DOC18/436862_02
Your Ref. DA 35/98 MOD 5

Section 75W Modification to the Chlor-Alkali Plant, Botany Industrial Park (DA 35/98 MOD 5)

The EPA has reviewed Ixom's Environmental Assessment available on the Department of Planning and Environment's (DPE) website titled "*Botany Repack Facility Environmental Assessment DA 35/98 Modification 5*" and provides the following comments below.

Figure 3 | Proposed Repack Facility Layout

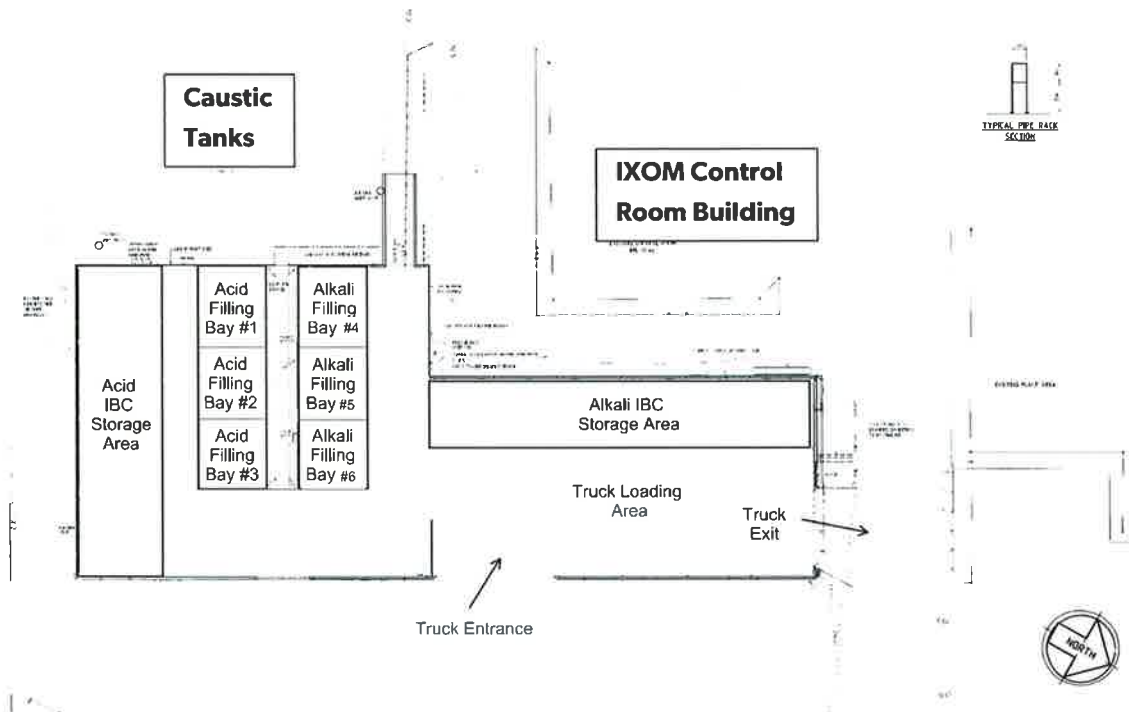
The EPA understands that Ixom proposes to install a new small scrubber for the vapours generated during the filling of IBCs and at the hydrochloric acid filling station. These vapours would be transferred to a stack and discharged to atmosphere. If the repack facility is approved the EPA would require more information on the scrubber and its controls.

While not explicitly stated in the Environmental Assessment, the EPA understands that the repackaging facility will only accept new, or cleaned and certified, IBCs and drums for filling. The facility will not be undertaking any washing, or container reconditioning activities.
